**Consultation Response from KC,
Lead Local Flood Authority**

2025/92242 Land off, Hermitage Park, Lepton, Huddersfield, HD8 0JU

**Reserved matters application (including consideration of appearance, scale and landscaping)
for the erection of 80 dwellings, pursuant to Section 73 approval 2025/90105 pursuant to
previous outline permission 2022/91735, and the discharge of conditions 6, 7, 8, and 9**

Date Responded: 19th September 2025

Drawing Title
Tree Protection Plan 2 of 2

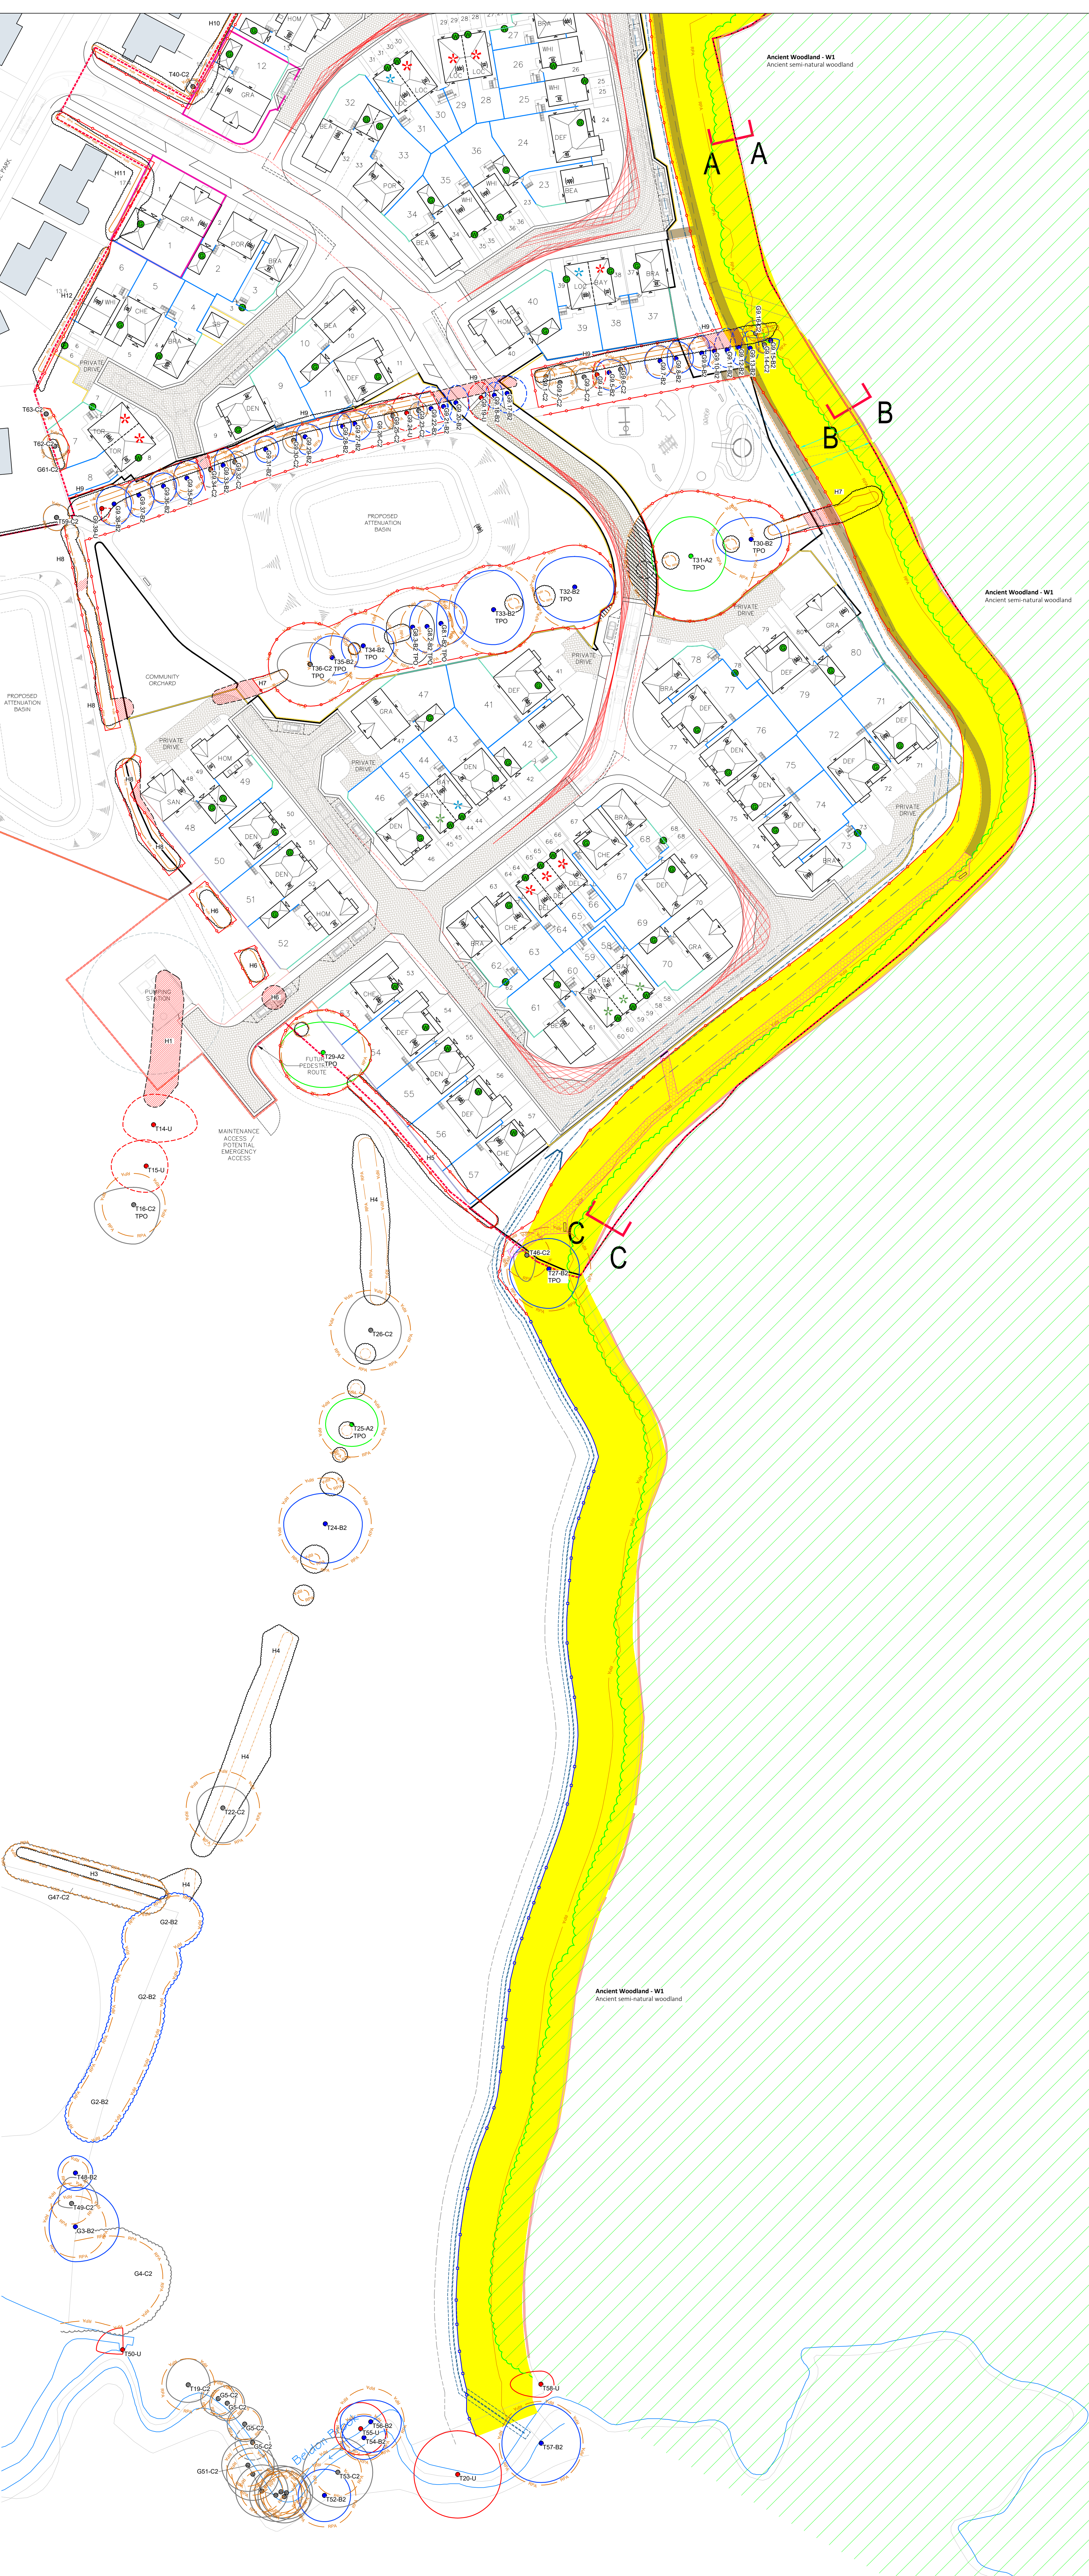
For the **Landscaping Condition, number 8**, we are not sure if it is relevant, but an overflow swale was to be incorporated into the landscape to protect new properties. This was abandoned due to clash with root systems for existing trees. It is now a piped system the opposite side of the public right of way with an inlet at the north end of the site and an outlet toward the south. It is important that the land at the north end is shaped so any flow from a watercourse to the rear of existing properties is channelled toward the inlet. Landscaped drawings need clarification as it appears to suggest this may not be the case. This is important as problems with the existing watercourse resulted in residents diverting flows into the site in previous years which is not acceptable but remains a risk that needs to be mitigated.
